Application No: AB/72/20/HH
Site Address: Riversong 19C River Road Arundel BN18 9EY
Description of works: Replace the existing balcony, rebuild boundary walls and other alterations. This application may affect the setting of the Arundel Conservation Area.

Thank you for your internet representation made on 21st July 2020 which has been recorded as an objection with the comments as follows:

OWPC28550

DRAWING
Proposed Arrangement

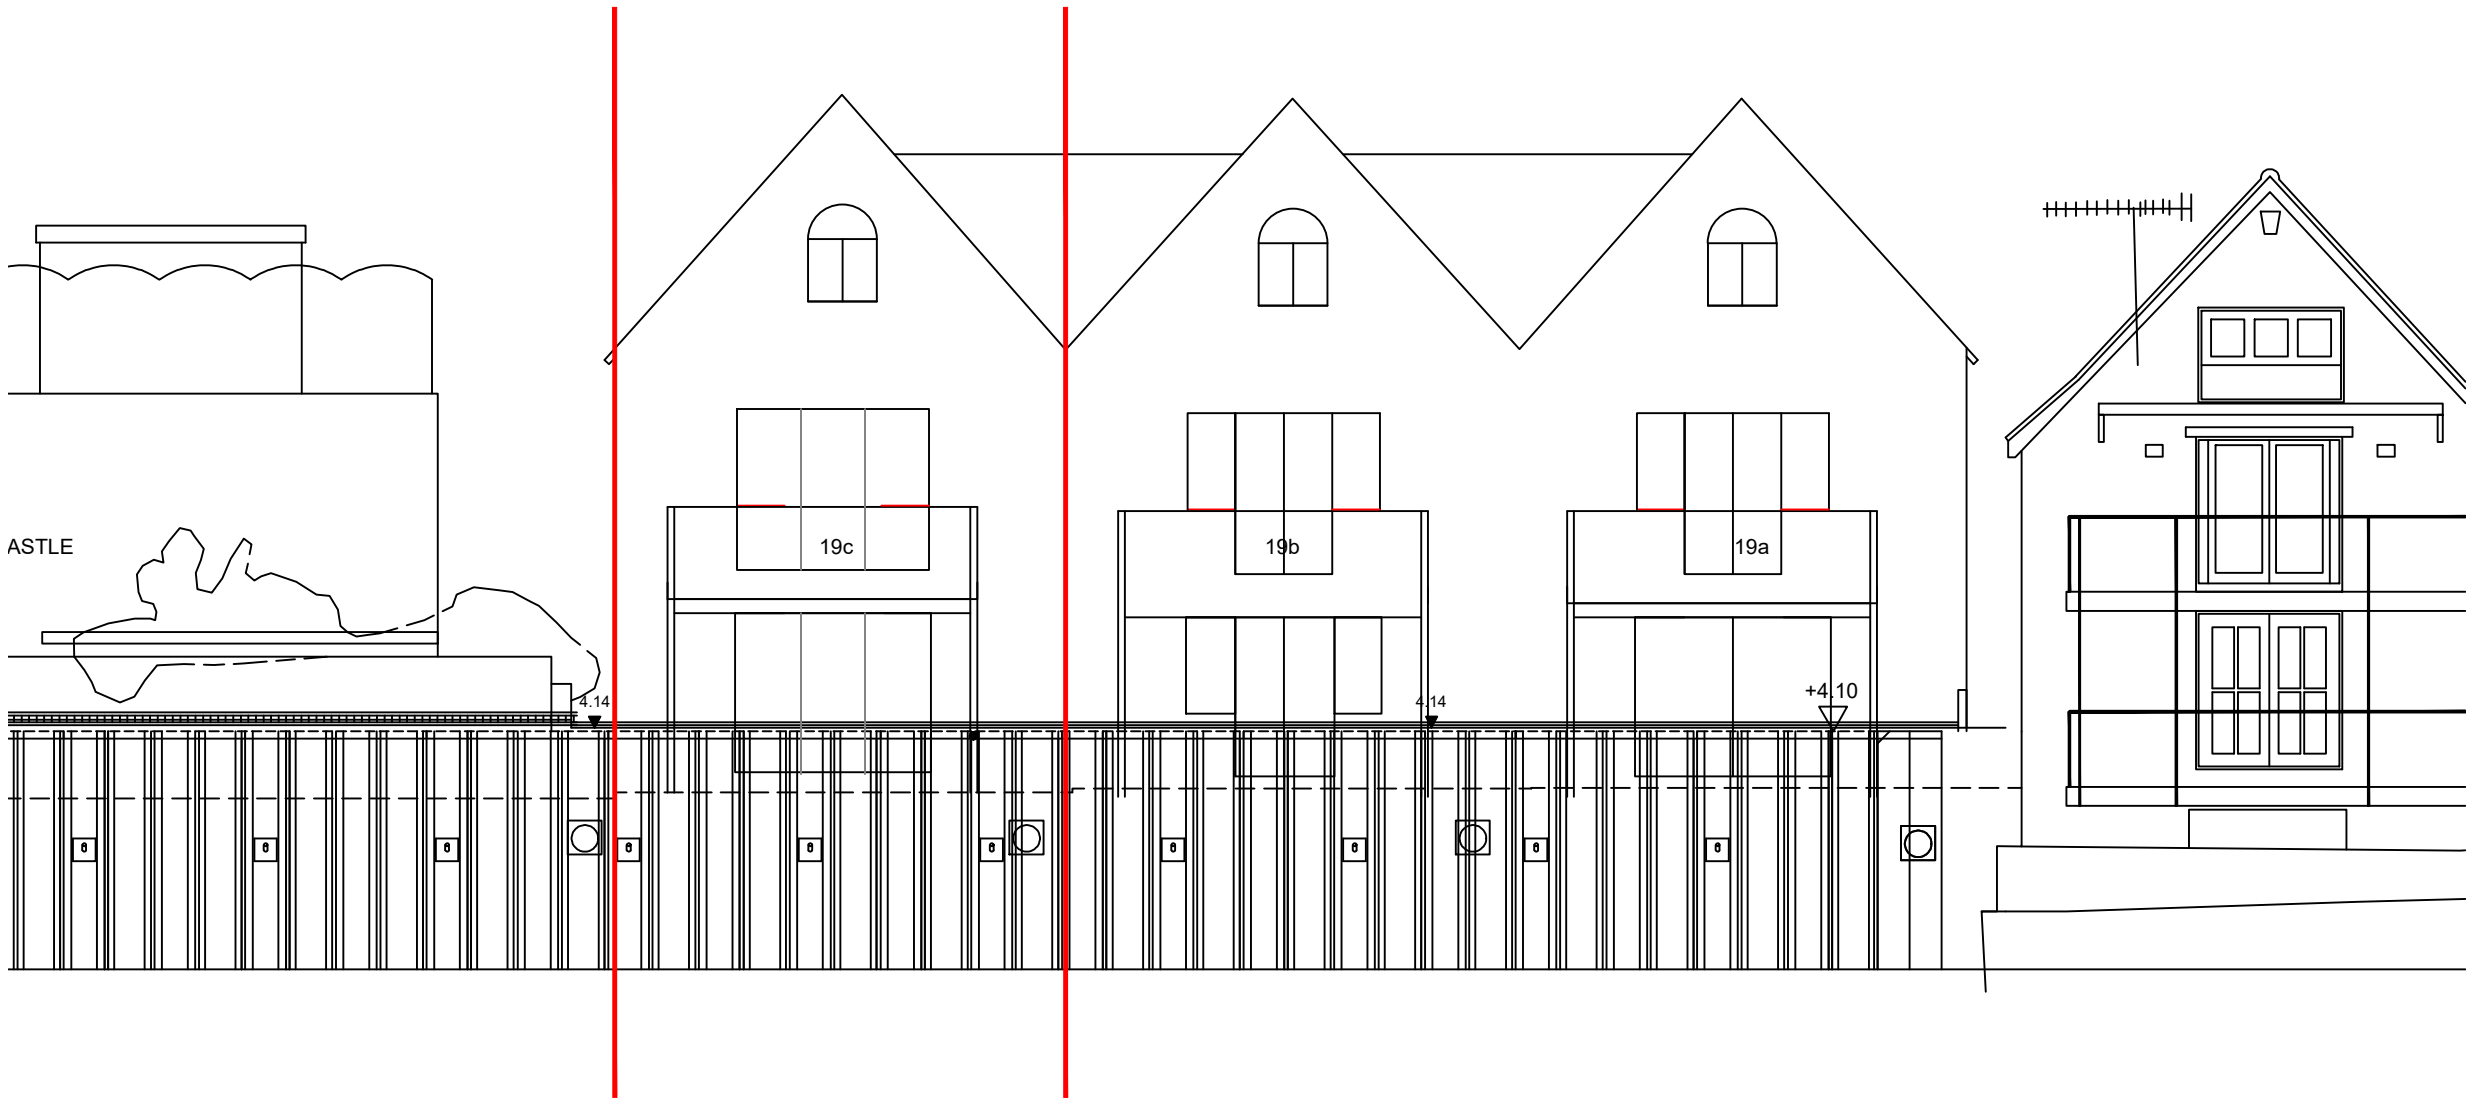
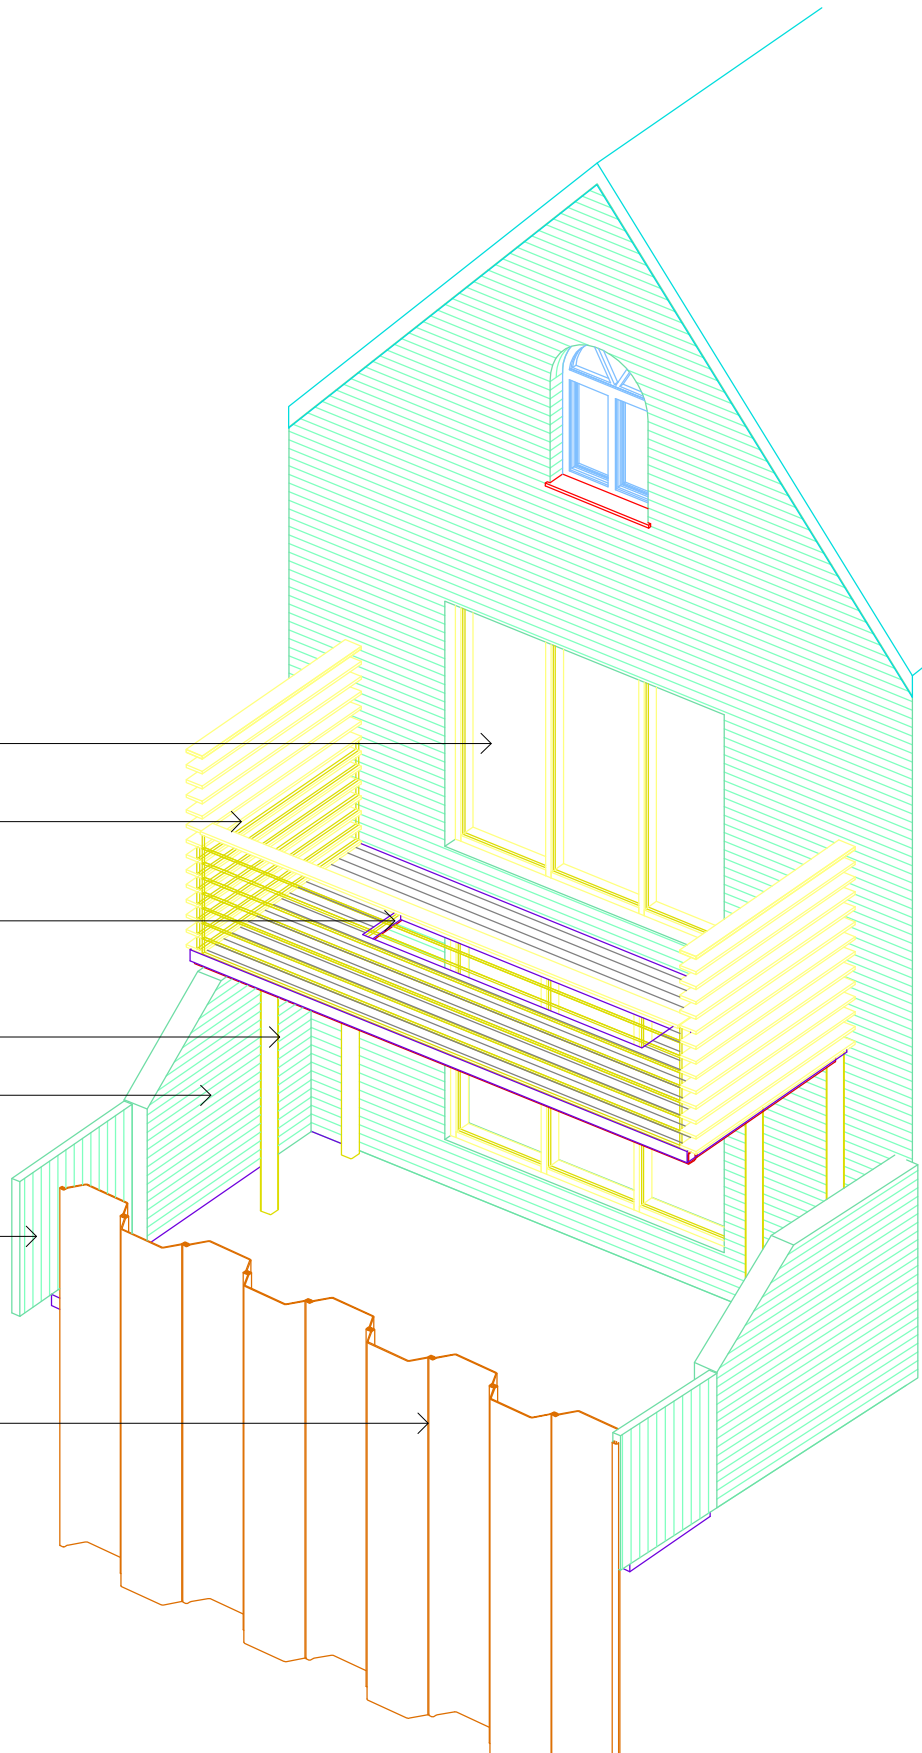
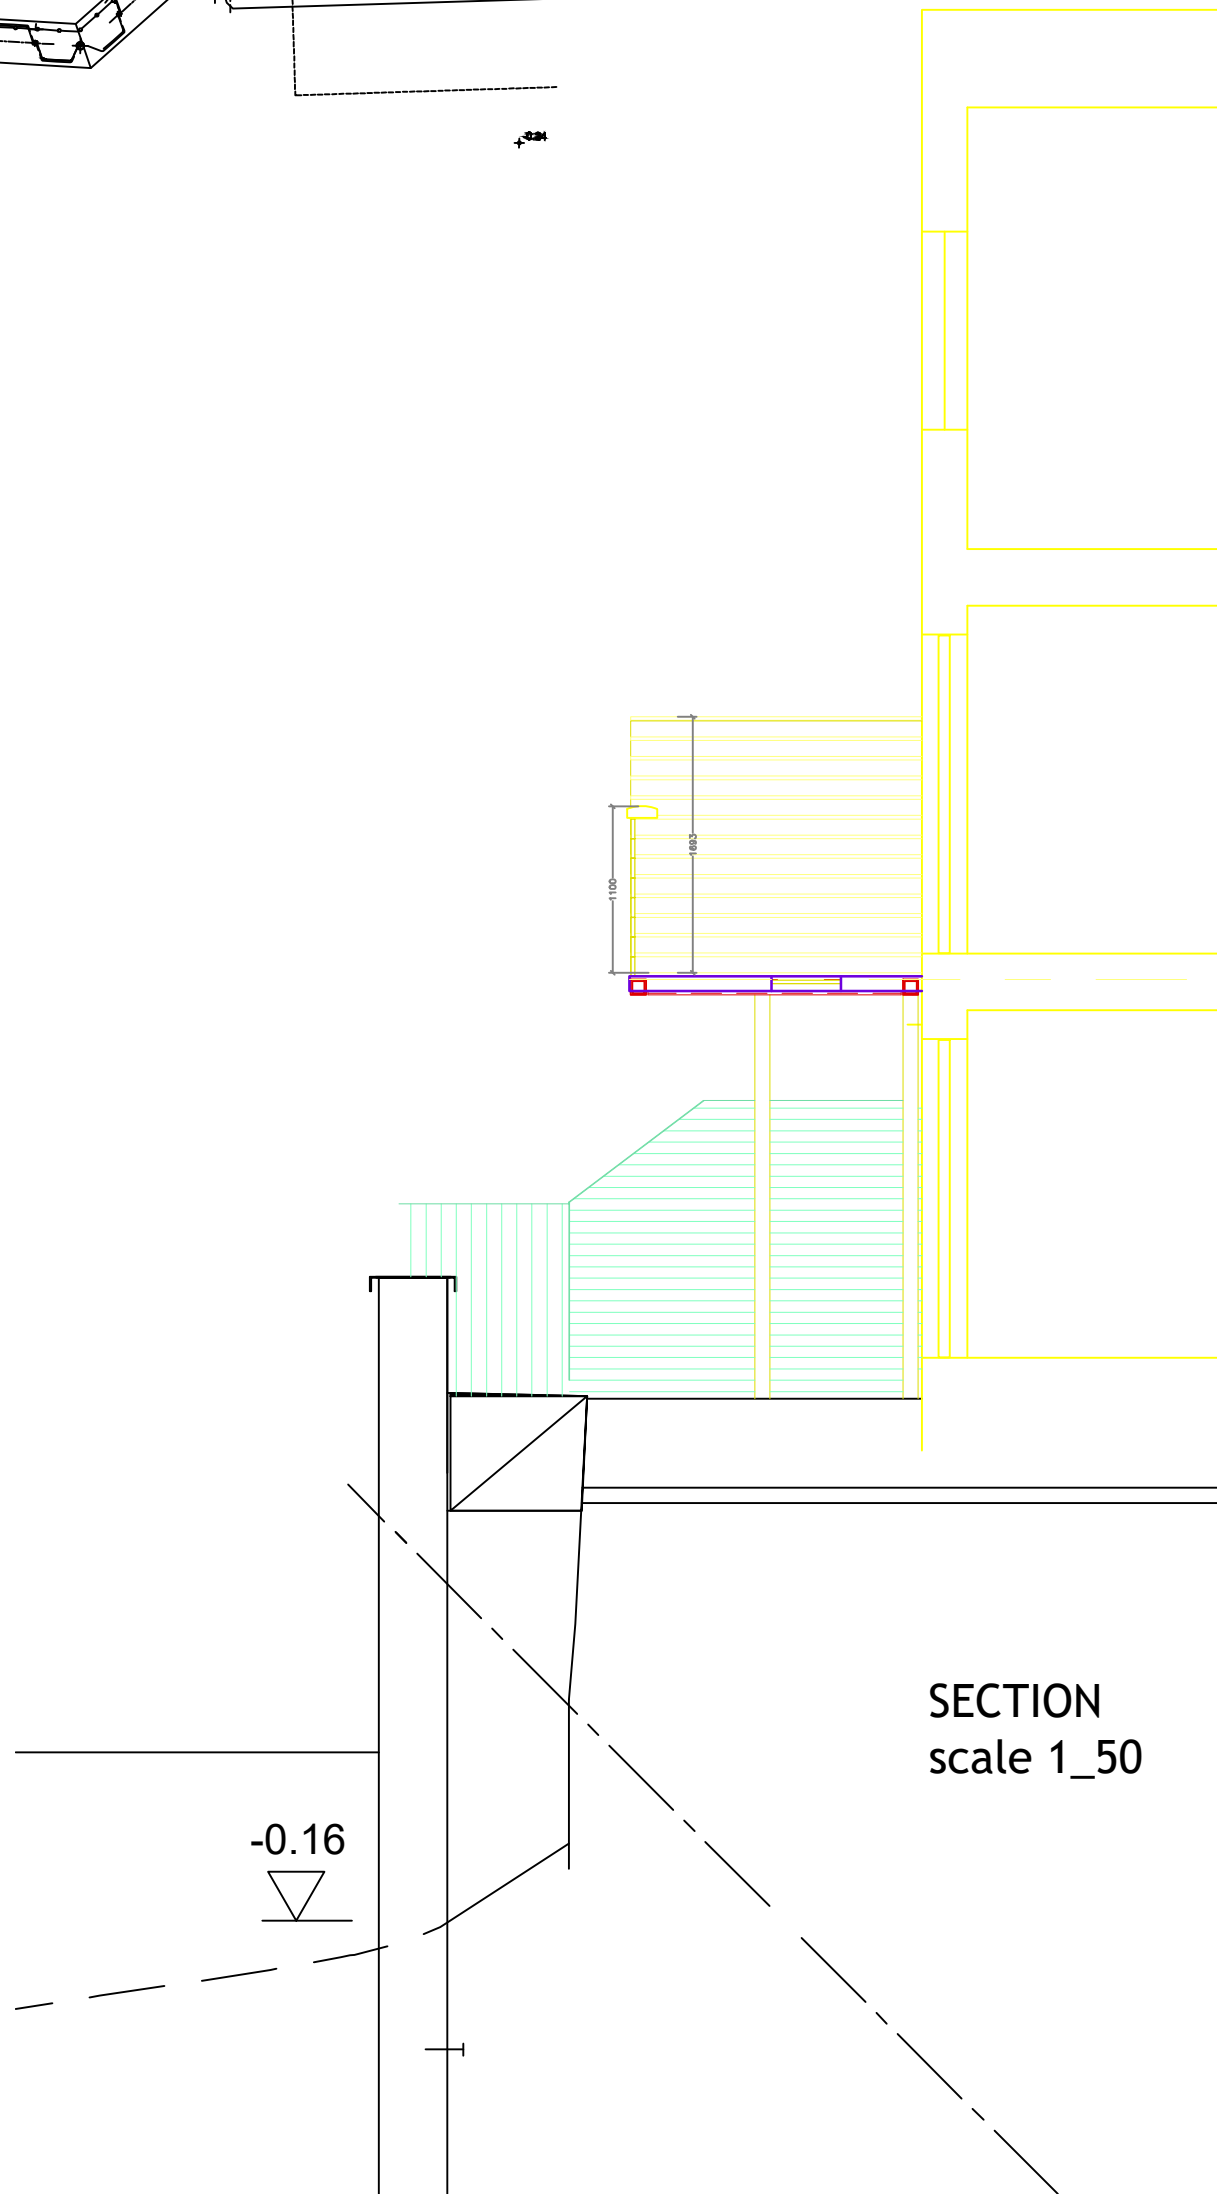
The three town houses have a distinctive symmetry of form, fenestration and detailing which is an intrinsic part of their design and appearance and hence also to their contribution to the conservation area. The concern of the Panel is that the new balcony will be larger than its neighbours and the replacement fenestration will be a distinctly different colour to that in the remaining river facade of the building and possibly of different materials. As such the attractive symmetry and consistency of detailing of the river elevation of the block will be adversely affected to the detriment of the appearance of the building and the conservation area. The setting of the adjacent Listed Building (The Boathouse) will also be compromised.

The heritage statement indicates that the adjacent balconies will also need to be replaced. Clearly, this then provides an opportunity to ensure that there is a consistent design of replacement balconies and fenestration across the river elevation of the block; a comprehensive rather than an ad-hoc approach.

For the reasons given, the Panel considers that the replacement balcony and changes to the fenestration of the building will fail to comply with the relevant paragraphs of the NPPF and policies contained in the ADLP relating to the protection of designated heritage assets and their setting.
